CITY OF ALBUQUERQUE  
PLANNING DEPARTMENT  
February 4, 2009  
DRB Comments

PROJECT # <sup>100-7646/</sup>1004677 APPLICATION # 09-70033

RE: Tract 131, MRGCD Map # 38

PLAT OF
LOTS 1 & 2
GARCIA PROPERTIES
DEVELOPMENT

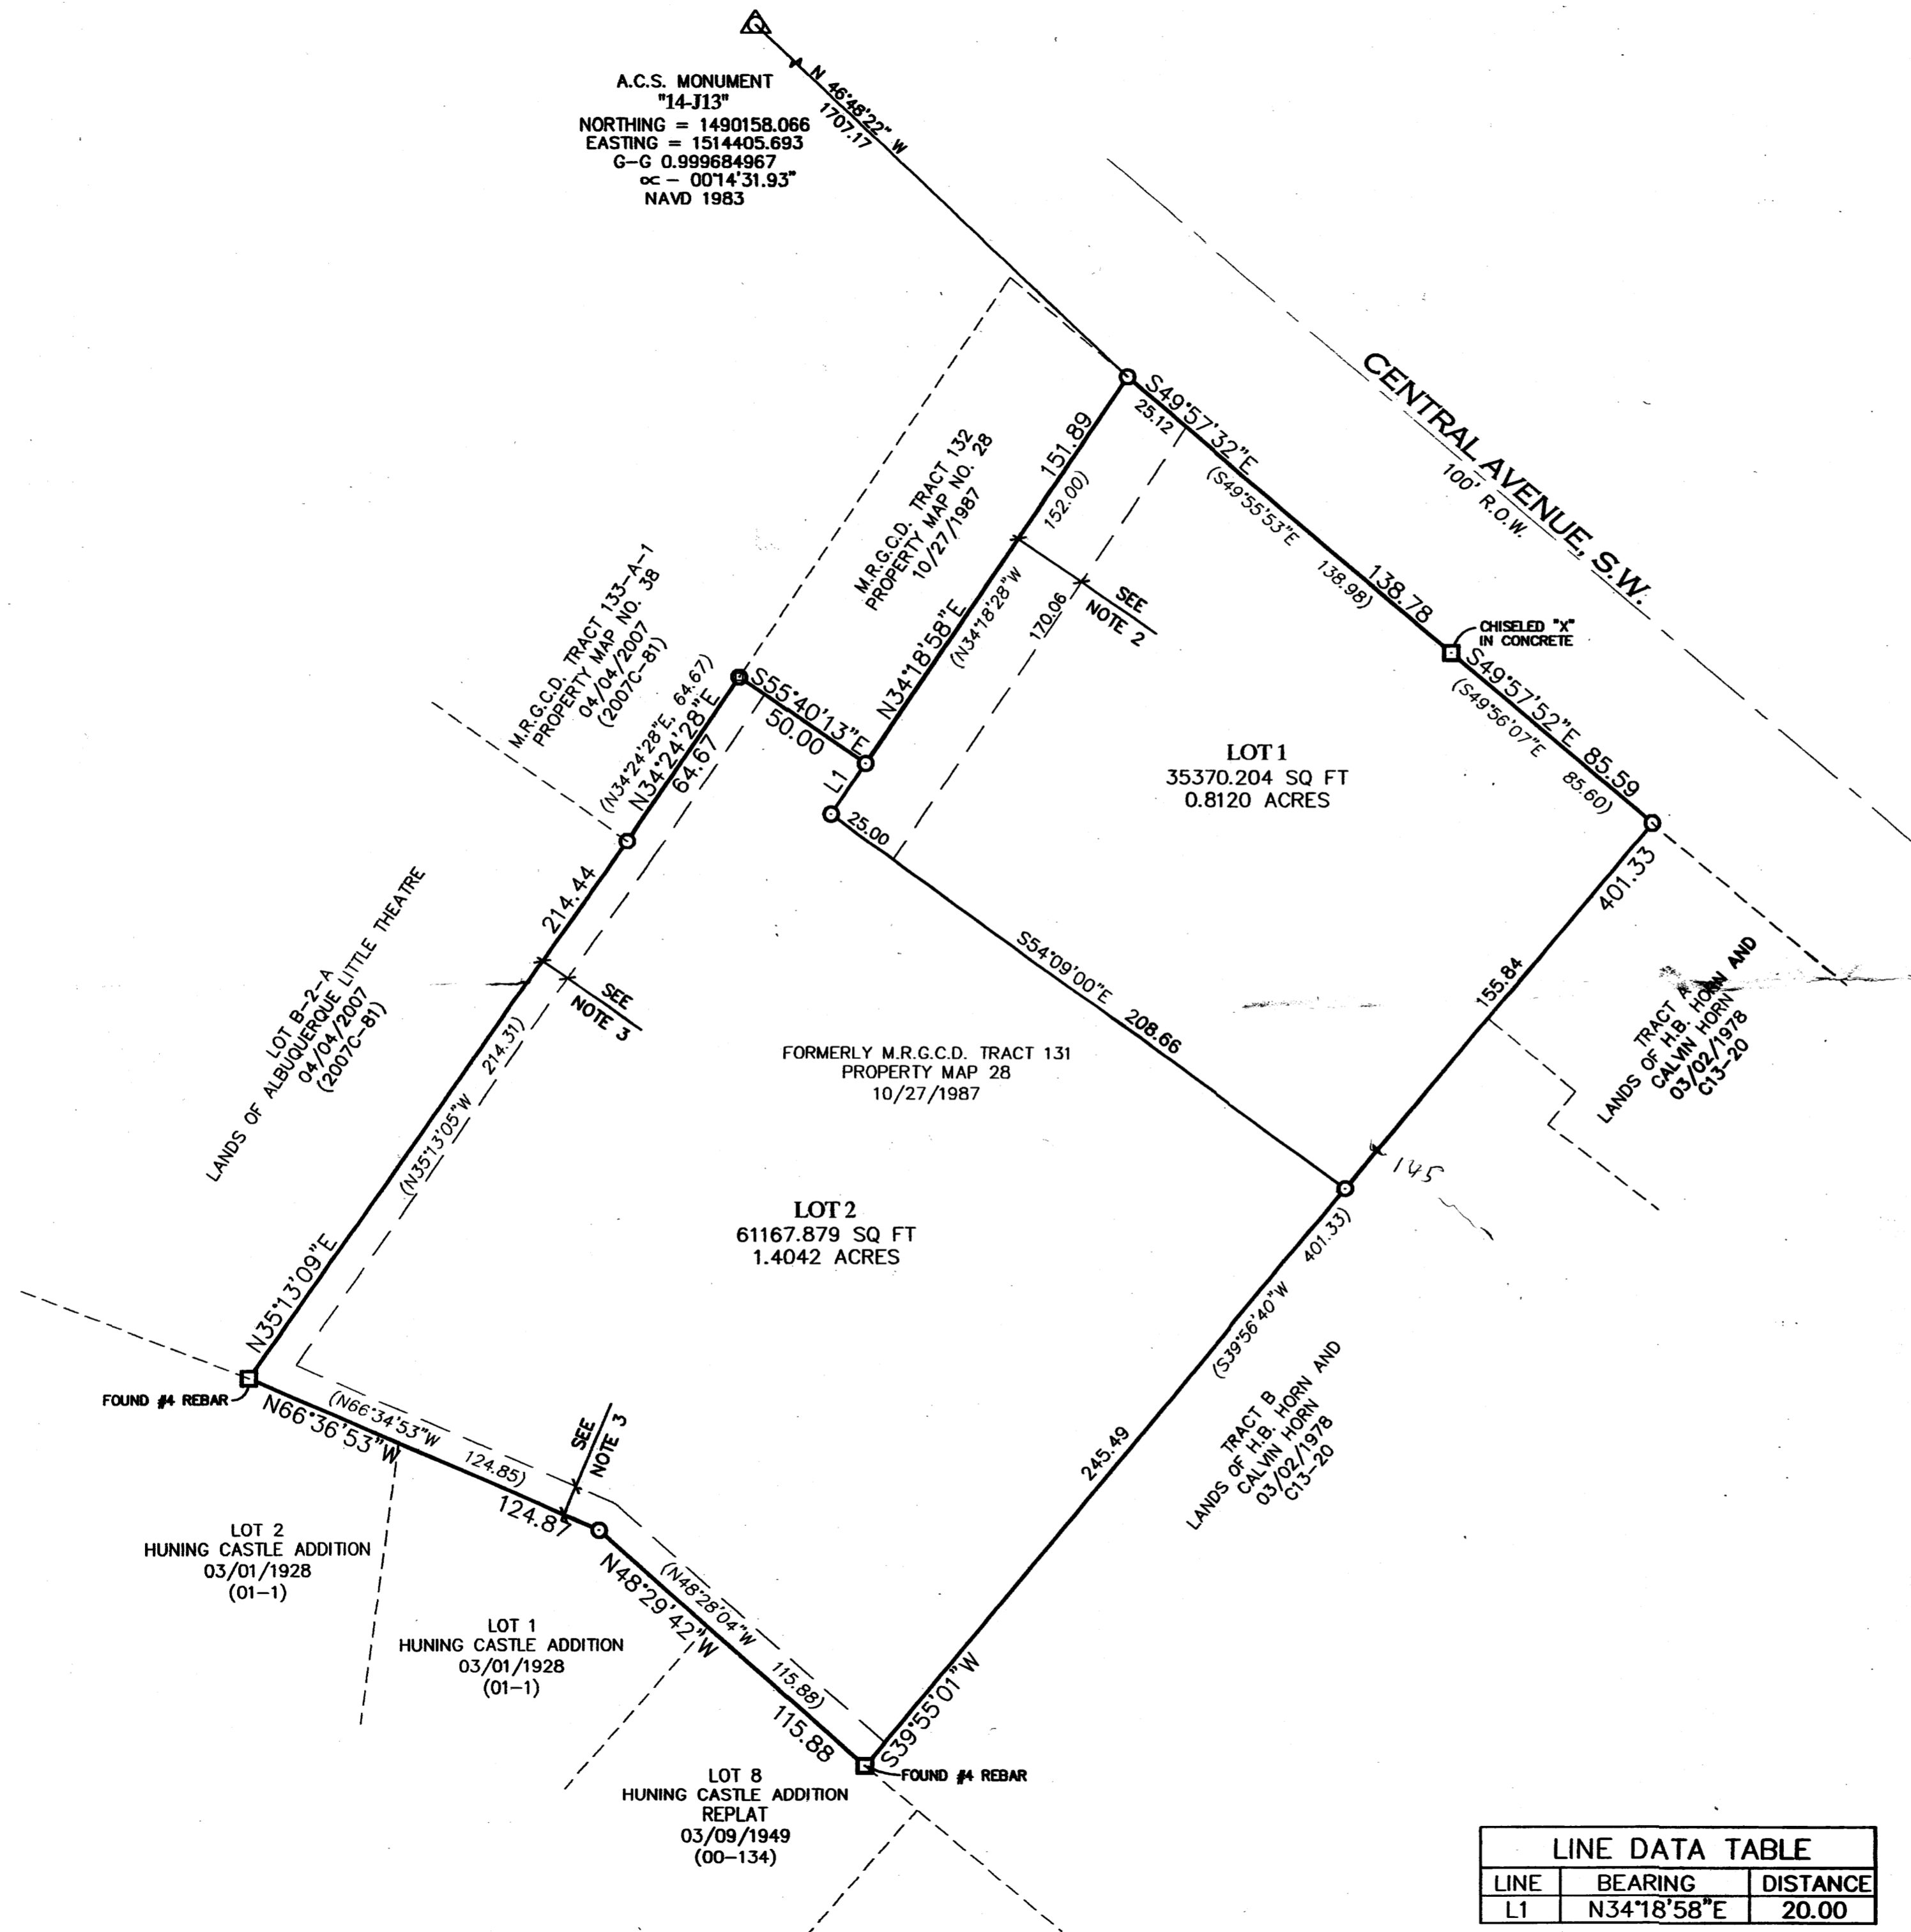
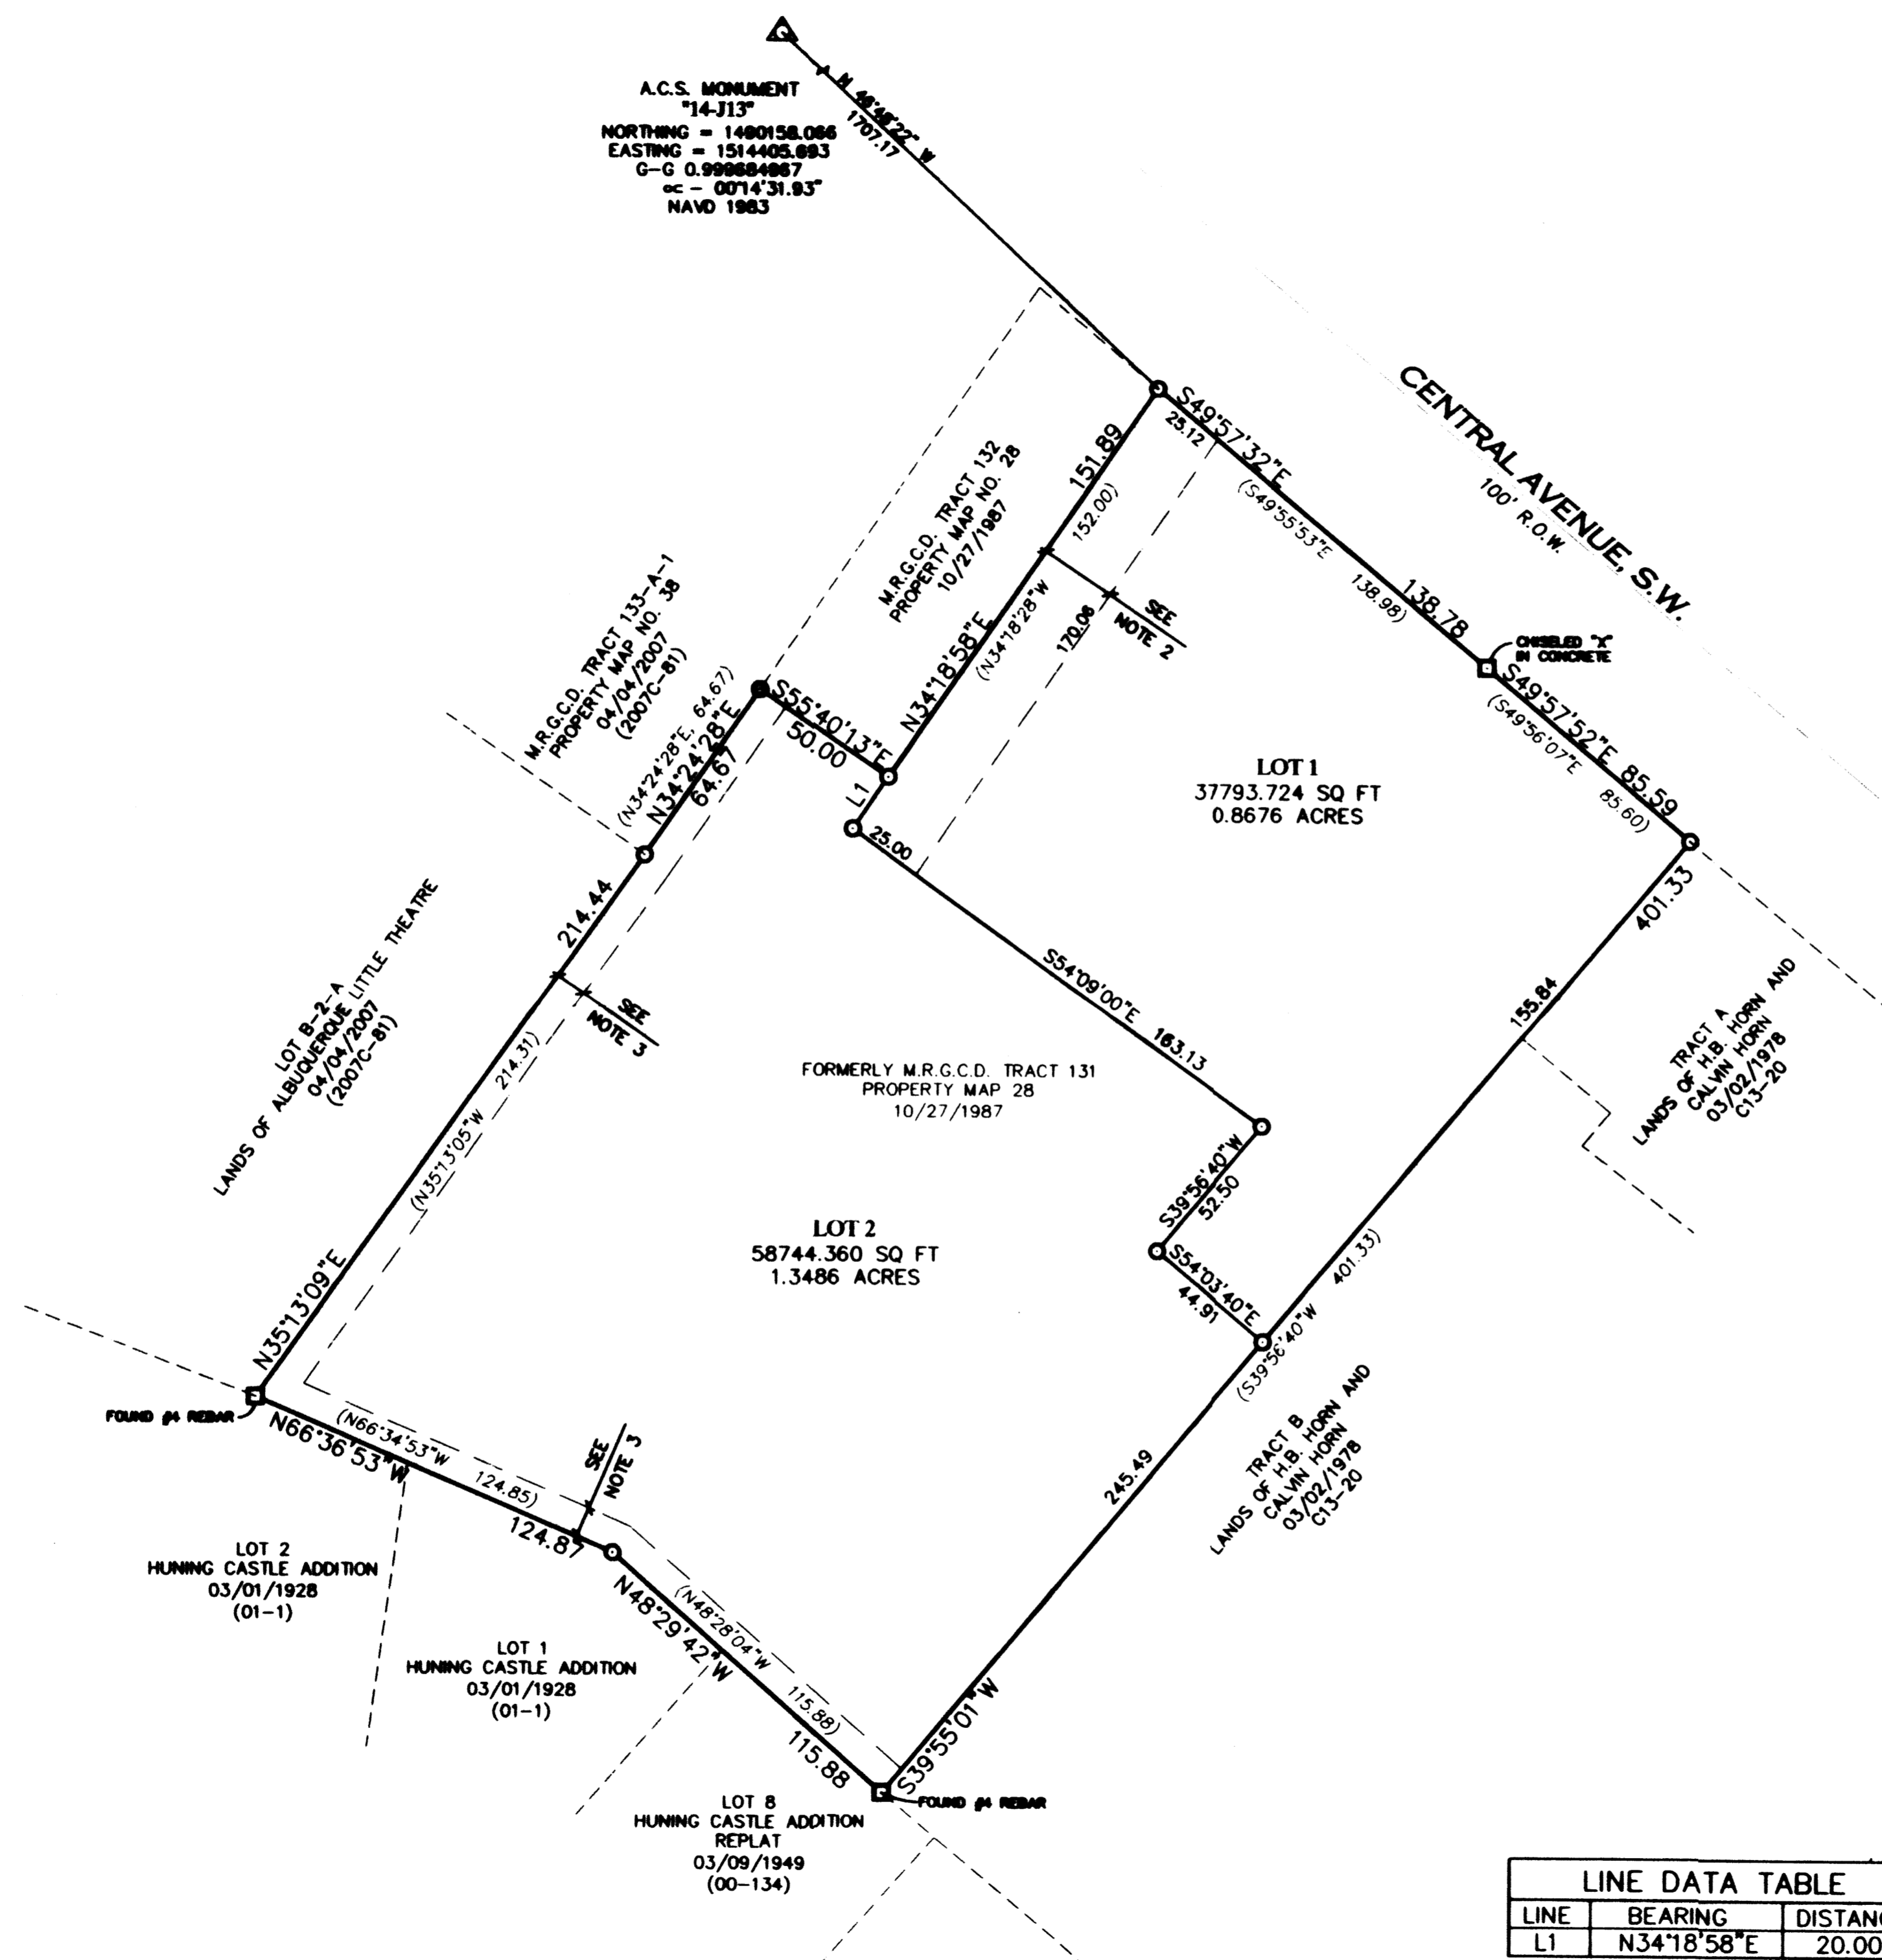
It appears Tract 132 needs to be a beneficiary of the proposed cross-lot easement.

A site plan with parking calculations is needed to demonstrate that required on-site parking per the Zoning Code is met on-site (on each lot). If proposed lot line goes through the existing apartments, an engineer or architect will have to certify that the property line wall complies with the Building Code, or the building would need to be removed prior to filing of the plat.

Please remove zoning note (I.) from Final Plat. For future reference, please revise Solar Note to be specific to this type of request, i.e. use the words "THIS PLAT" (rather than the words "REQUESTED FINAL ACTION") at the beginning of the note, and do not use the words "OR SITE DEVELOPMENT PLAN FOR SUBDIVISION" at the end of the note.
